Rule 17 - Deadline 4 Response

SUBJECT: Viking CCS Pipeline

APPLICANT: Chrysaor Production (UK) Limited

**NORTH EAST LINCOLNSHIRE
COUNCIL**

FIGURE TITLE
FIGURE 1
LANDSCAPE PLAN
WASHINGDALES BLOCK VALVE STATION
SHEET 1
ISSUE PURPOSE
ENVIRONMENTAL STATEMENT
PROJECT NUMBER / REFERENCE
 60668955 / VCCS_230620_ES_2

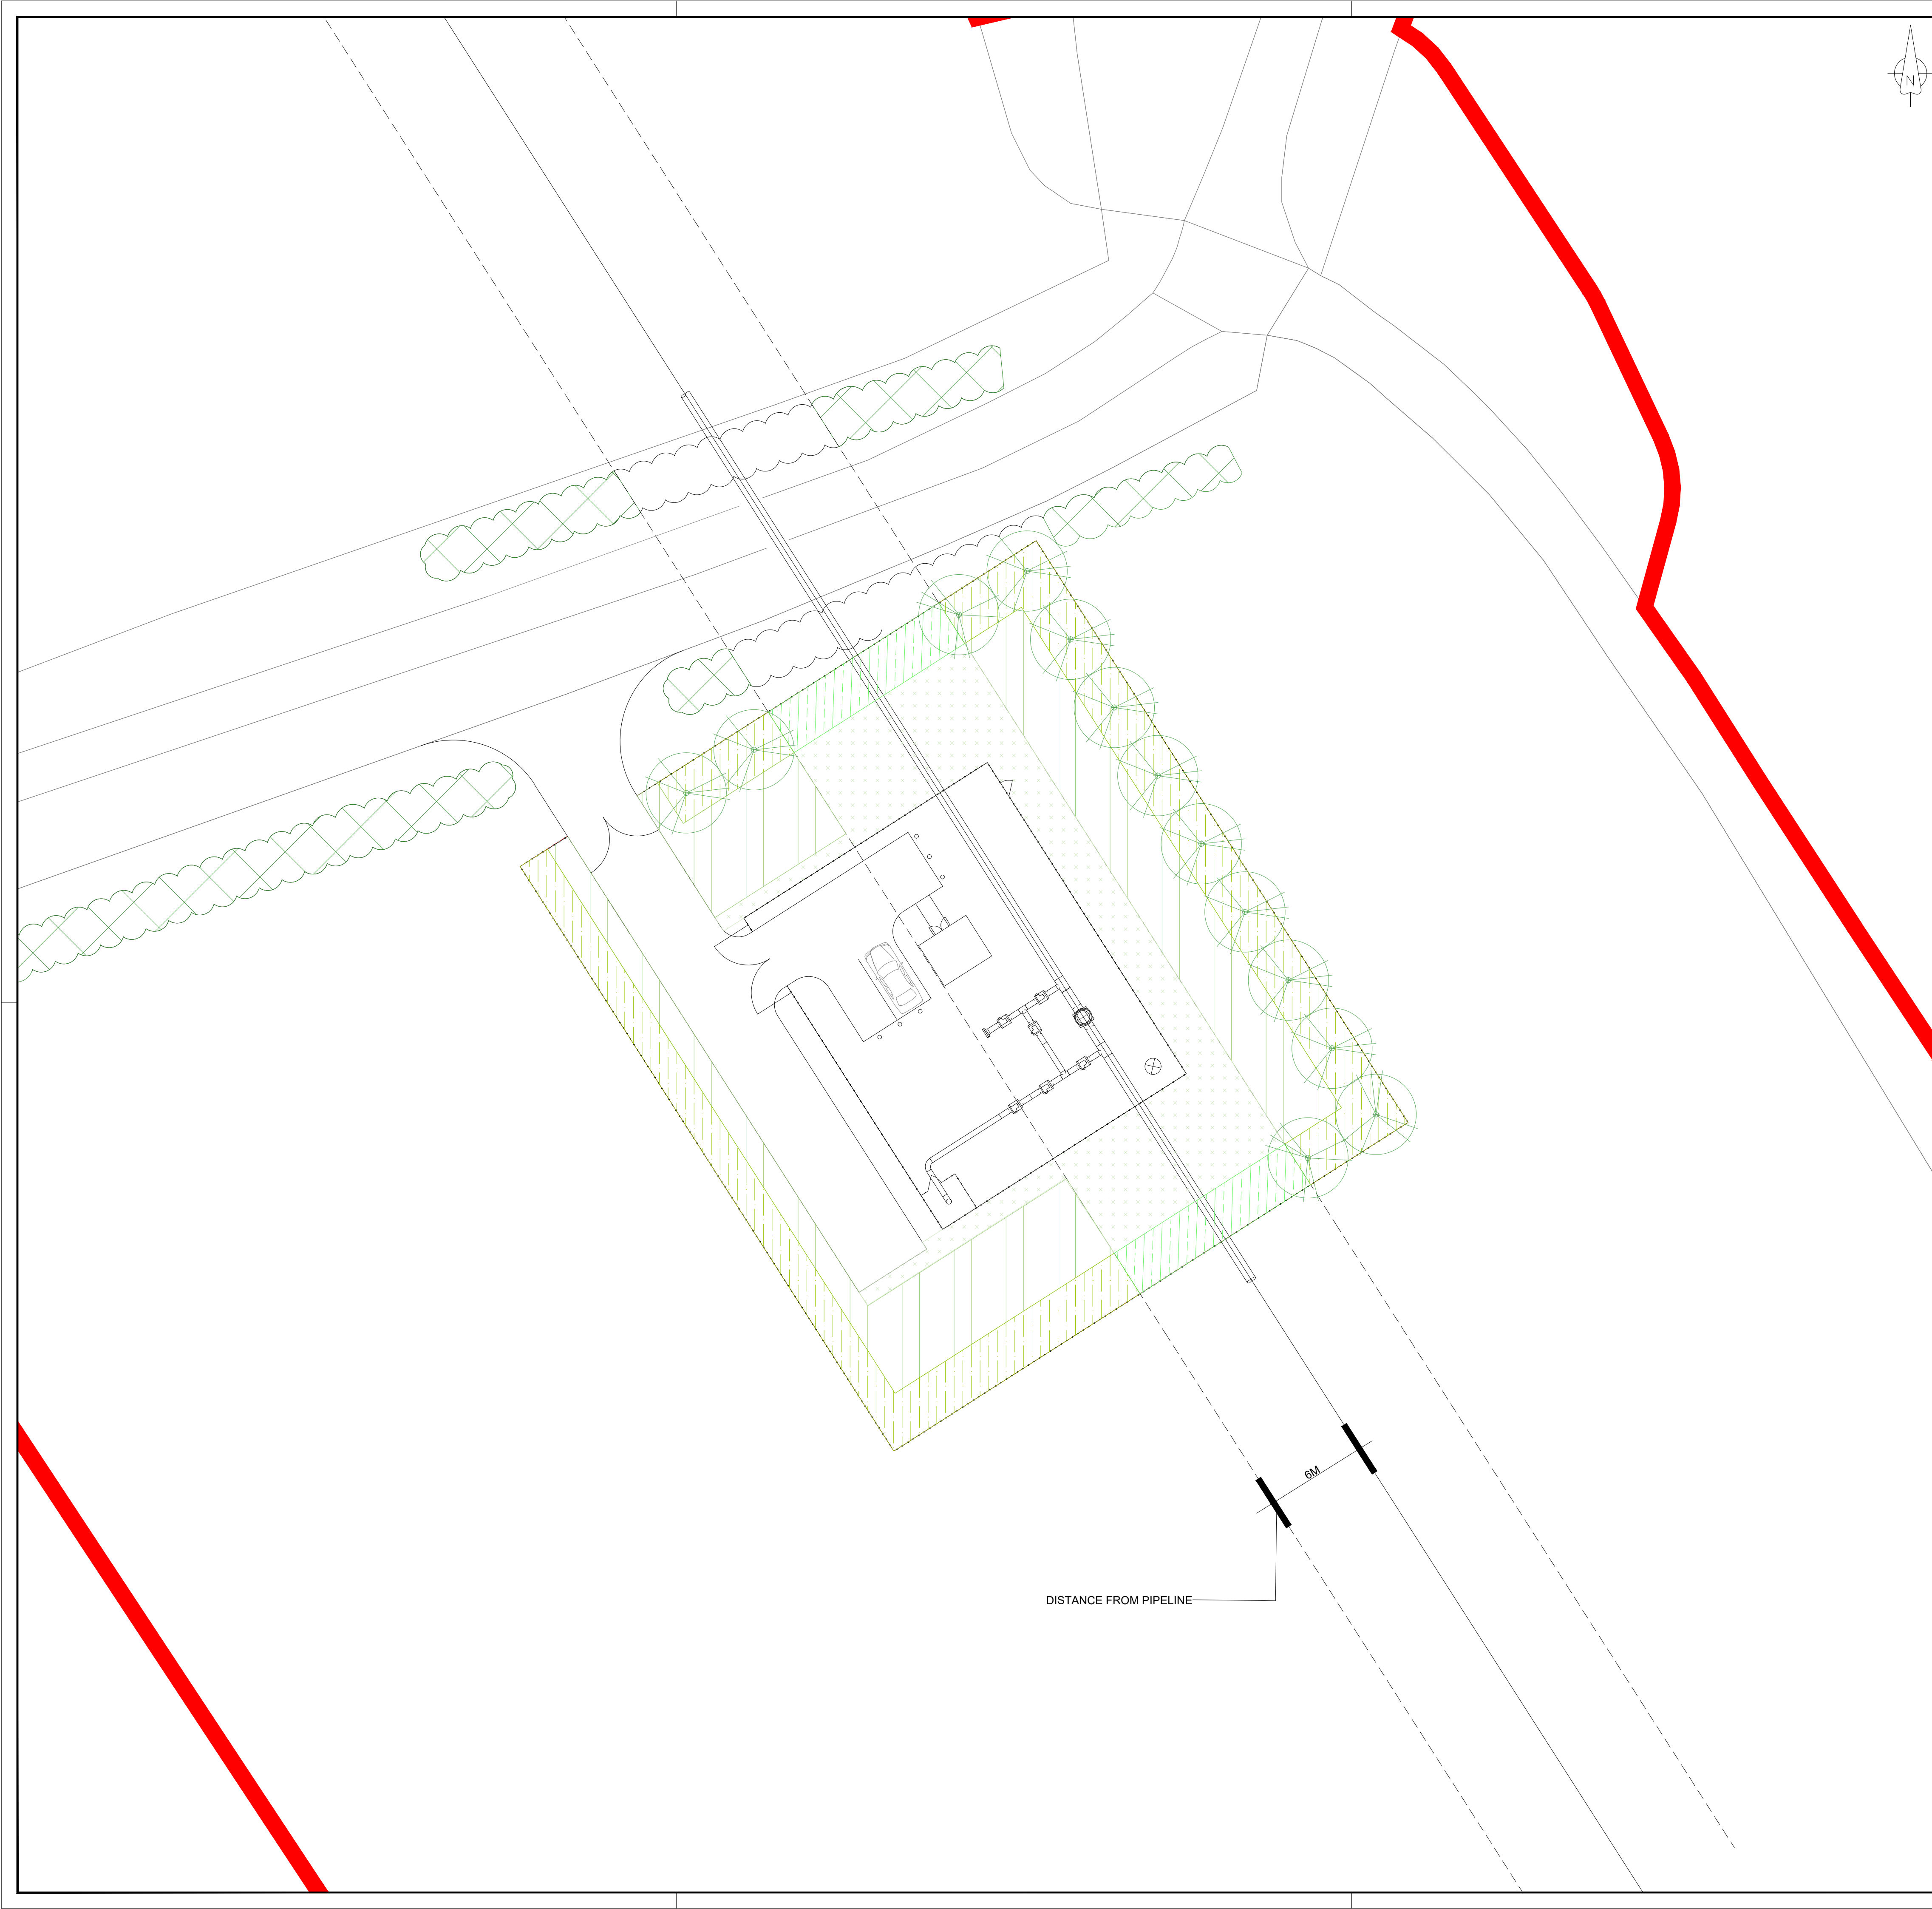
The CEMP and OLEMP do not show measurable gains although 6.8 Outline Landscape and Ecological Management Plan does show landscape plans with species lists and sets out appropriate management, including methods and timelines, of created habitats, such as the grasslands and hedgerows, and a monitoring programme. It states within the CEMP that a 10% net gain in biodiversity will be achieved which would require numerical values to be applied and that isn't present in these documents or others that I can see. The habitats present along the route have been mapped using Phase One which should be converted to the UKHab mapping system, and the Statutory Metric used to calculate baseline and post-construction biodiversity values as that capability now exists. That would provide the evidence that a gain and a 10% gain had been achieved or not which currently can't be ascertained from these documents. The Plan also states that where habitats are impacted, they will be returned to, at minimum, the same state and condition as they were pre-works. If it stated that an improvement in habitat type or condition would be applied post-construction, it would suggest there would likely be a gain in biodiversity but still unmeasured.
